Project Name : Land off Camp Road, Upper Heyford

Job No : 22-192

Note Title : Highways Technical Note

Date : September 2023

Road 1  
Horiz. 1:500 Vert. 1:50

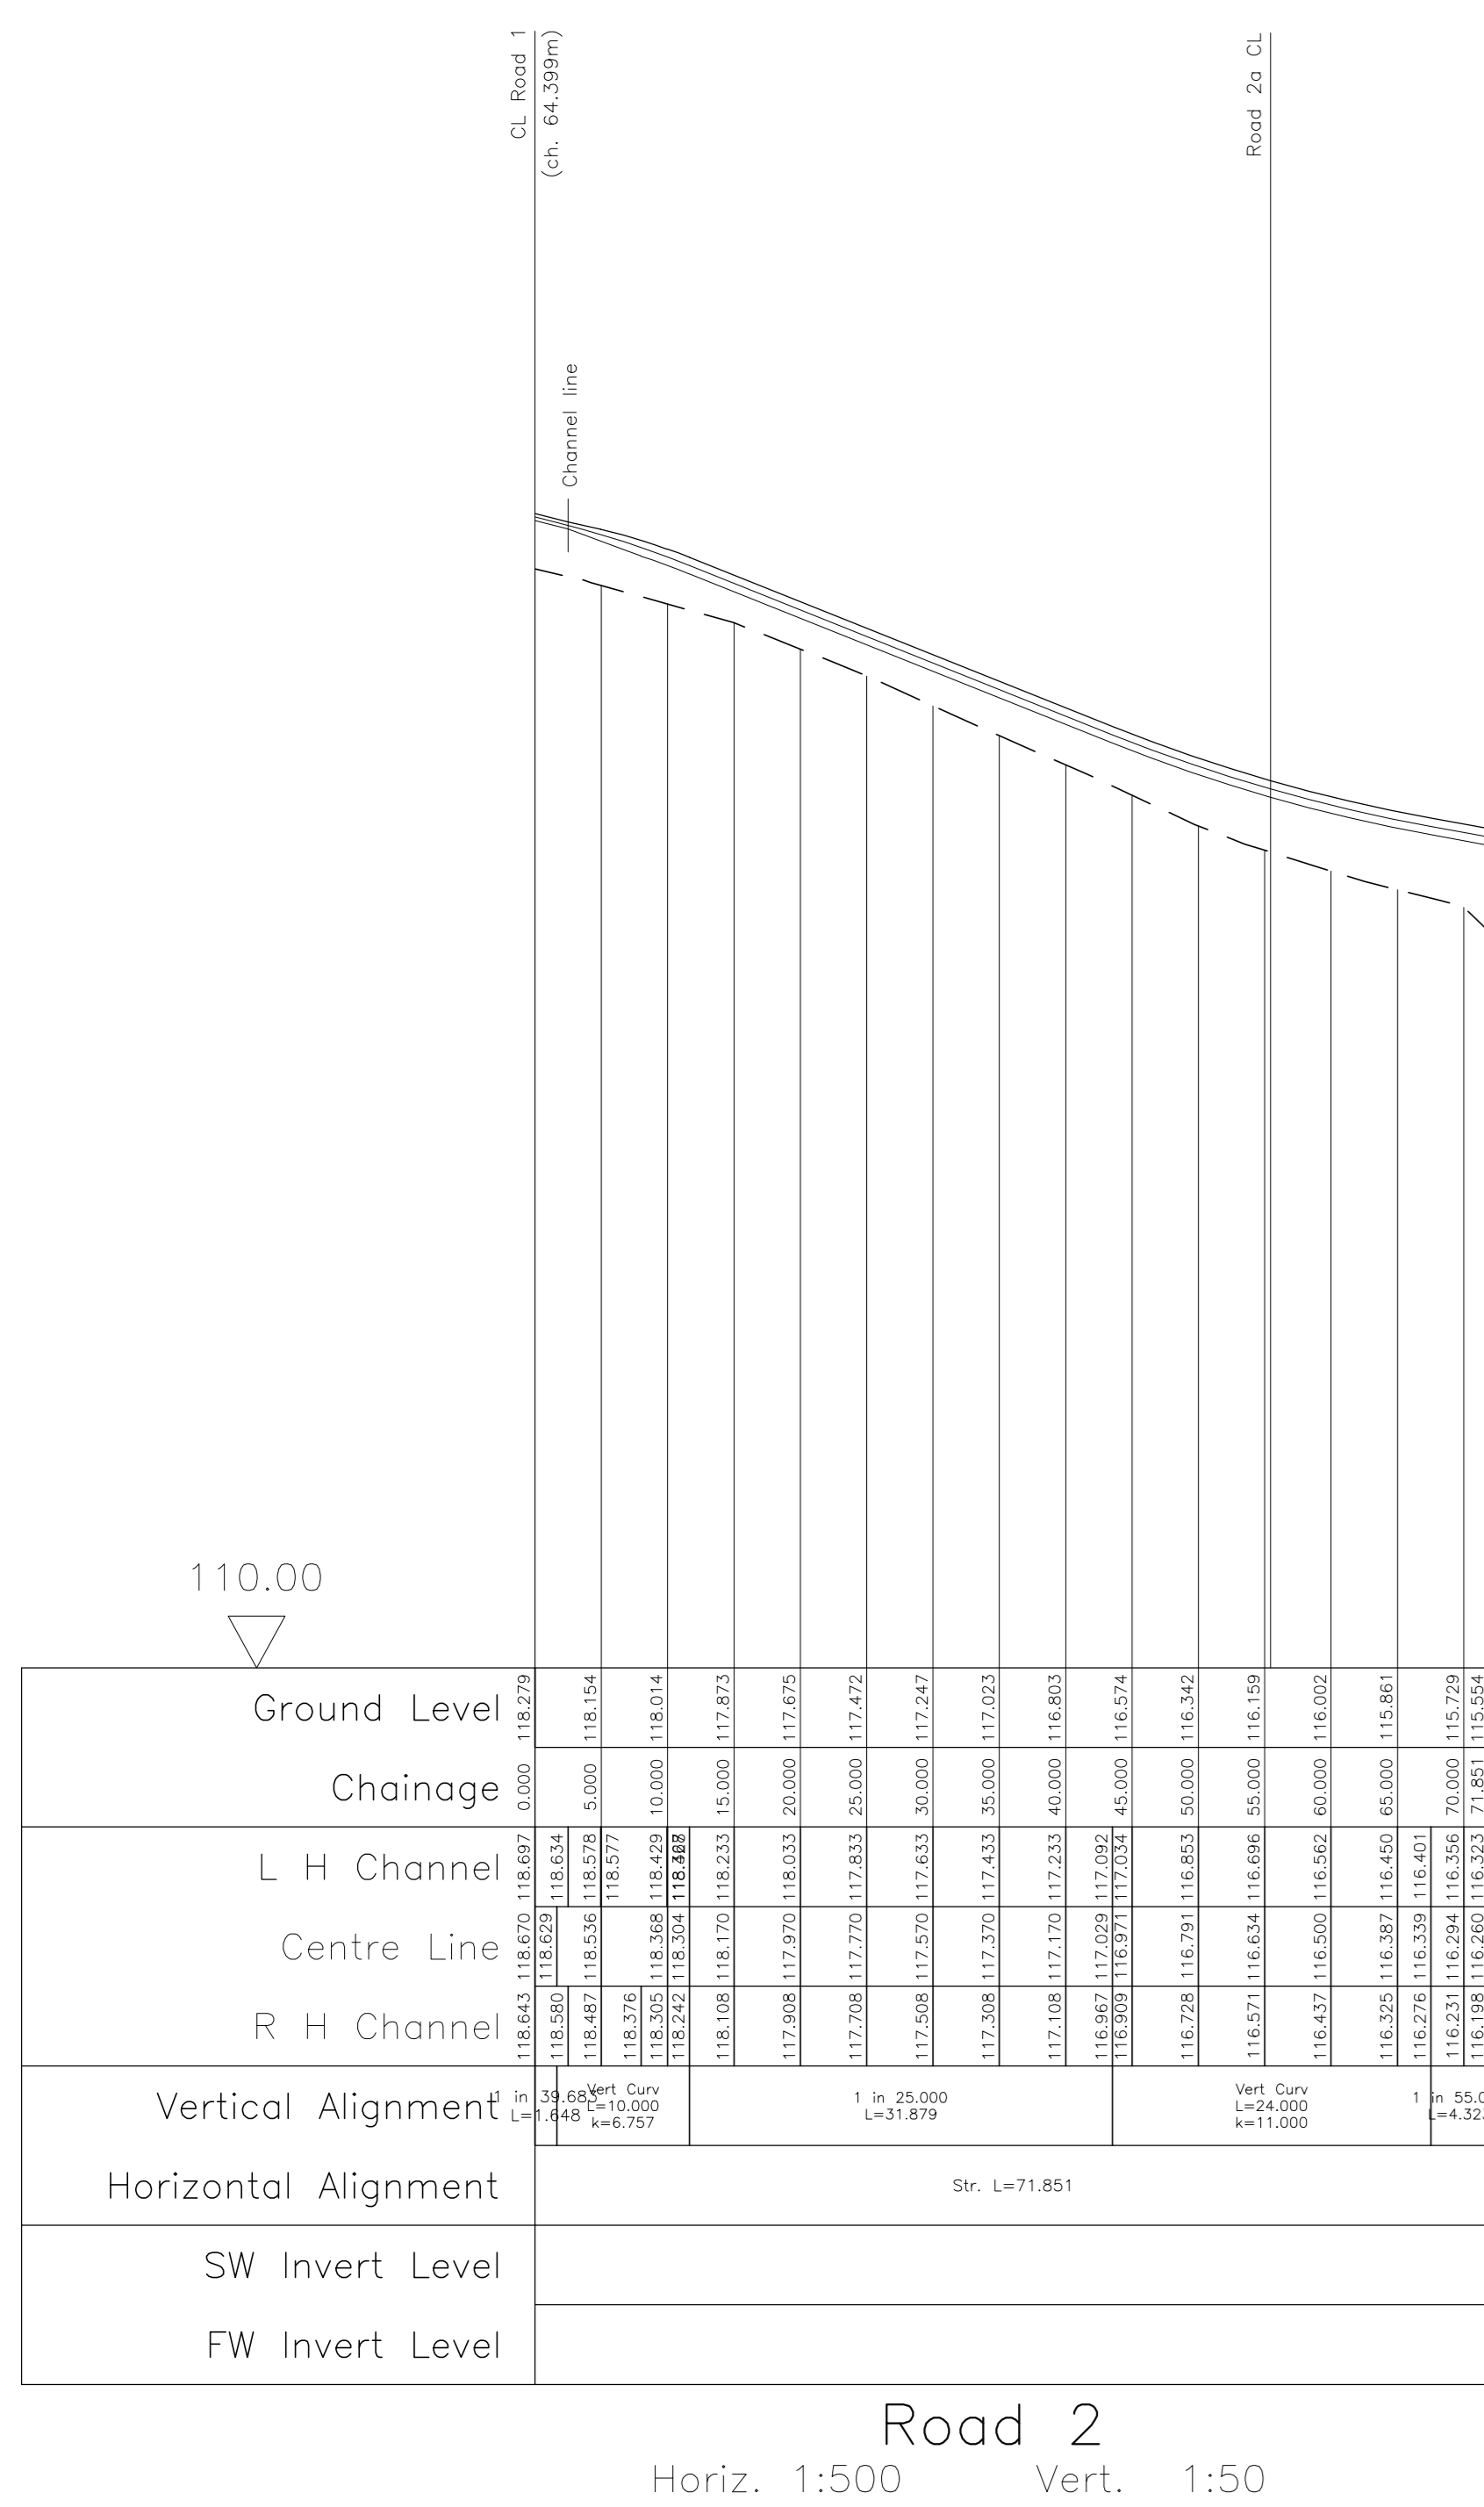
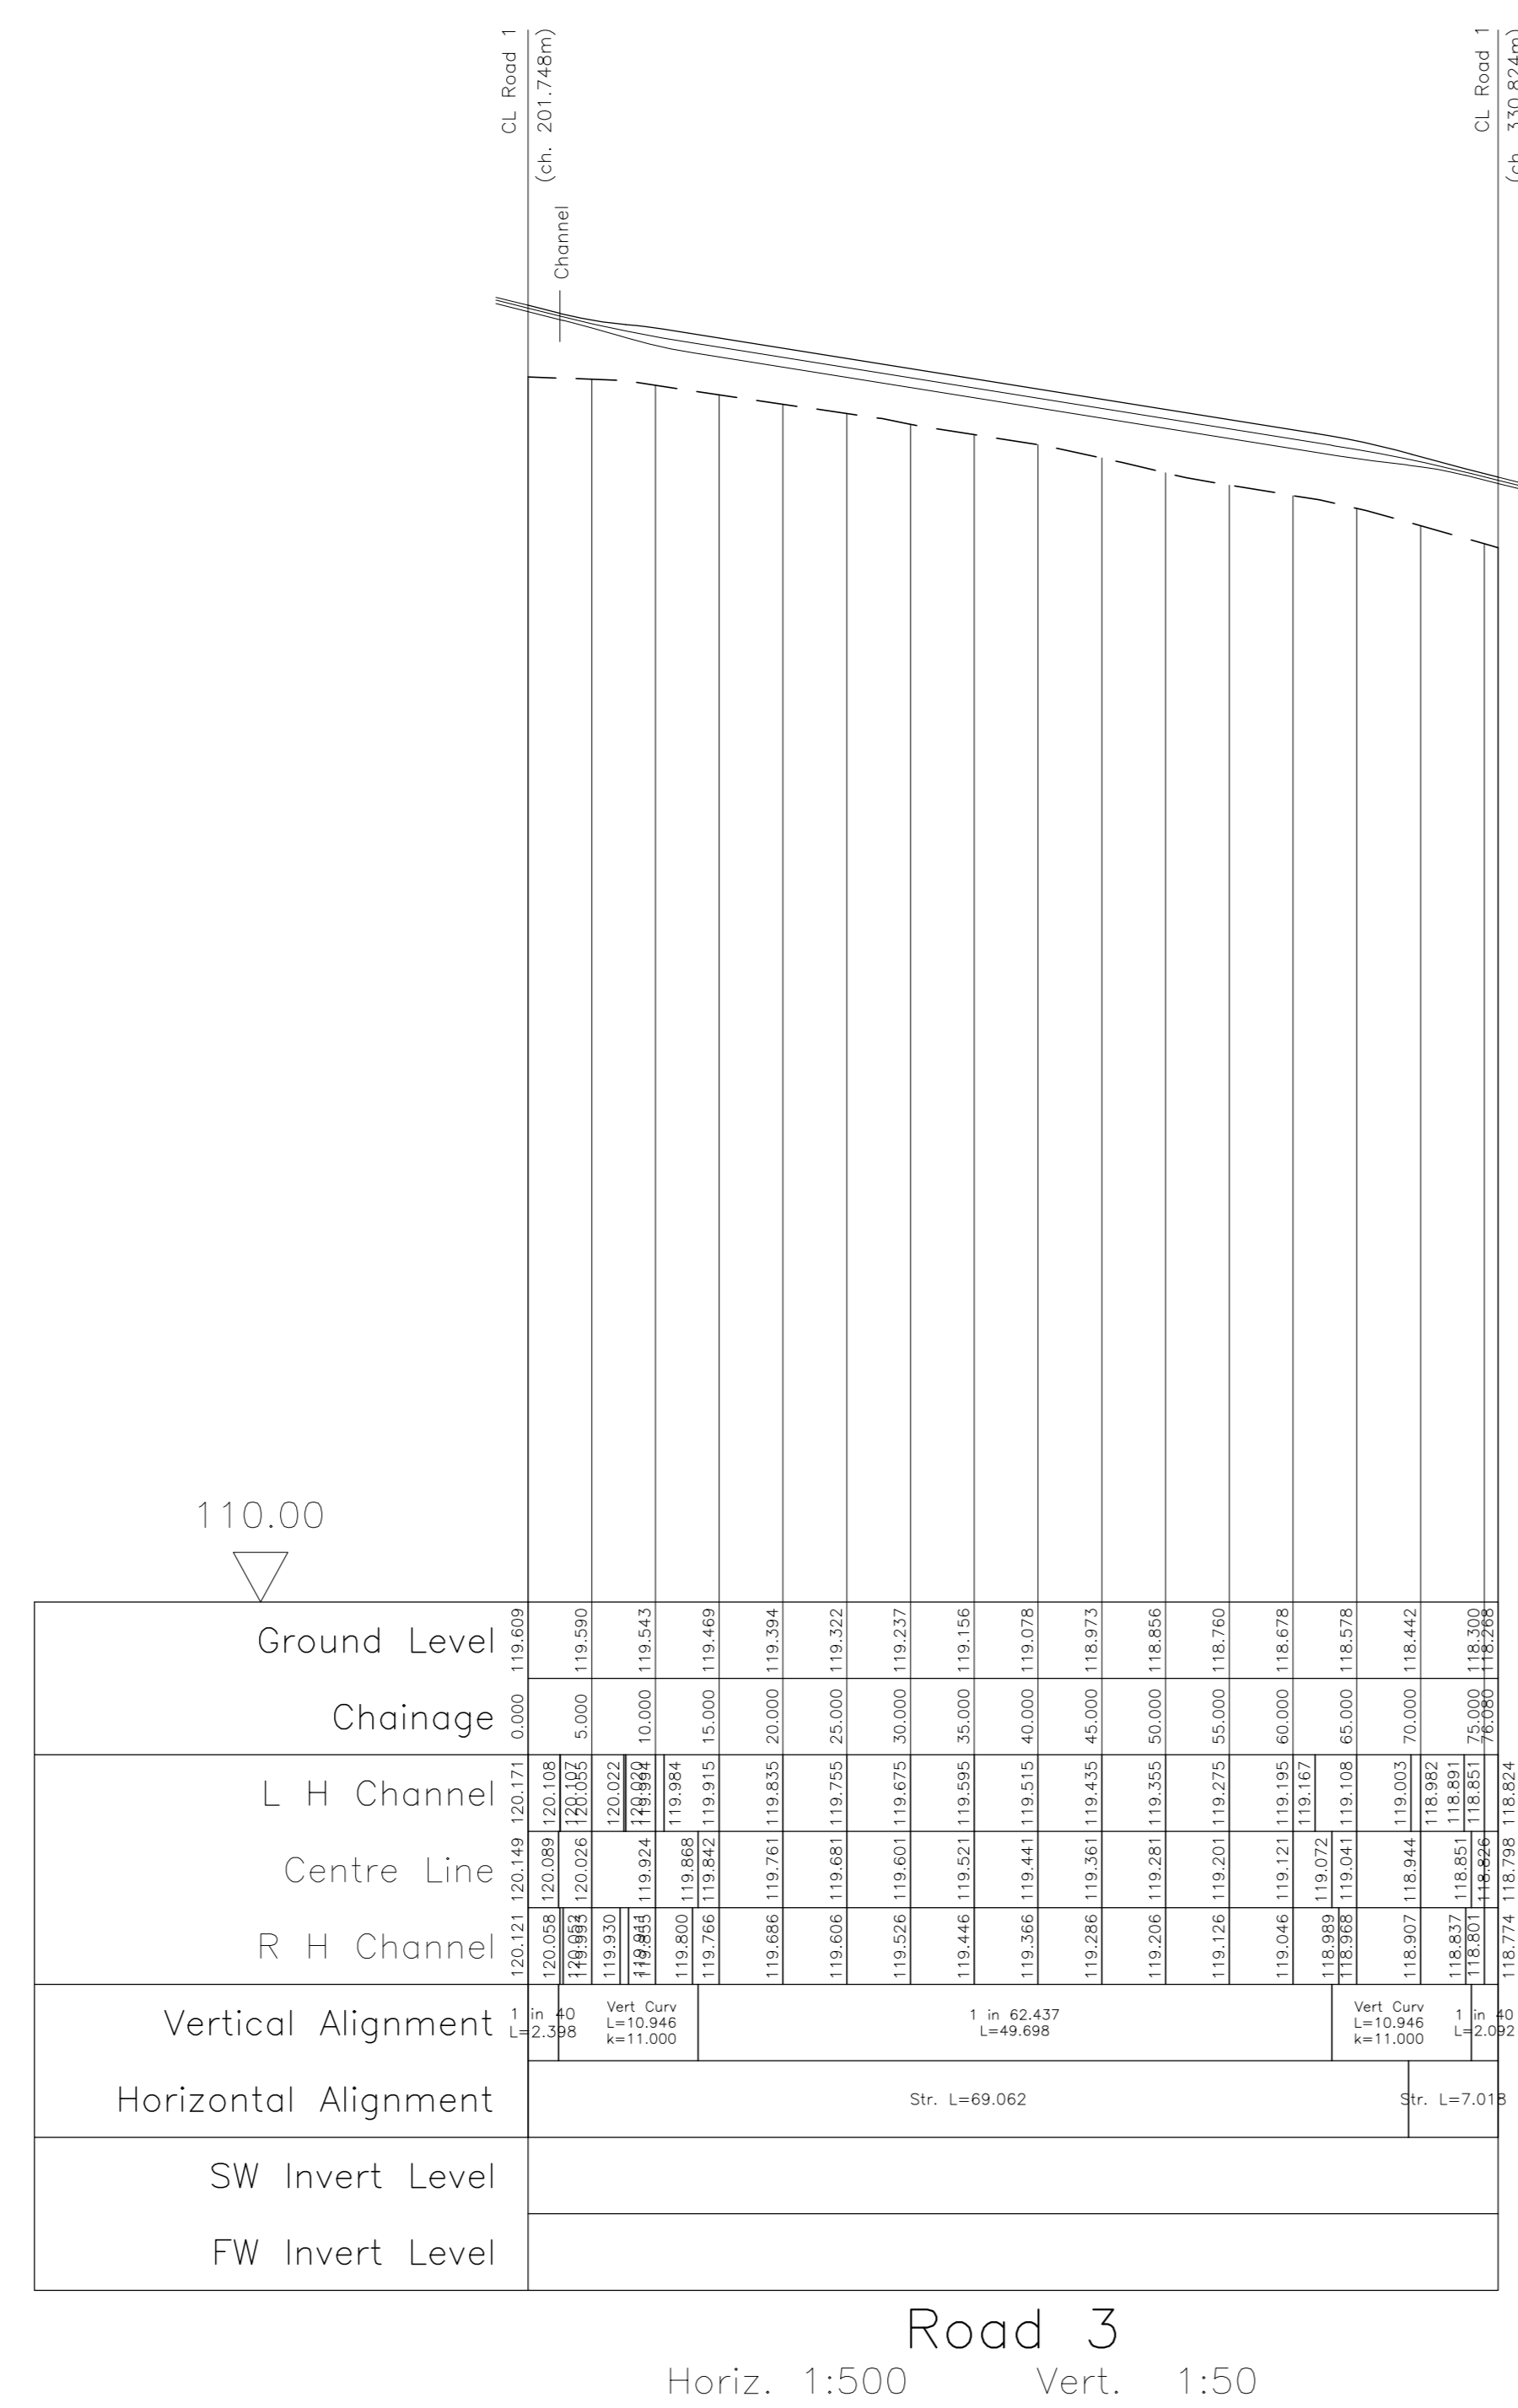
- A long section indicating the vertical alignment will be required to determine appropriate carriageway and footway gradients. They will need to be DDA compliant i.e. maximum 1:20 or 5%.

2.2.15 As requested by OCC Highways a number of long sections of the spine road have been produced to demonstrate the gradient of the adoptable highways; gradients are less than 1 in 20

(5%) and are therefore compliant with the Disability Discrimination Act (DDA). This is shown on **Drawing 22-192/109**.
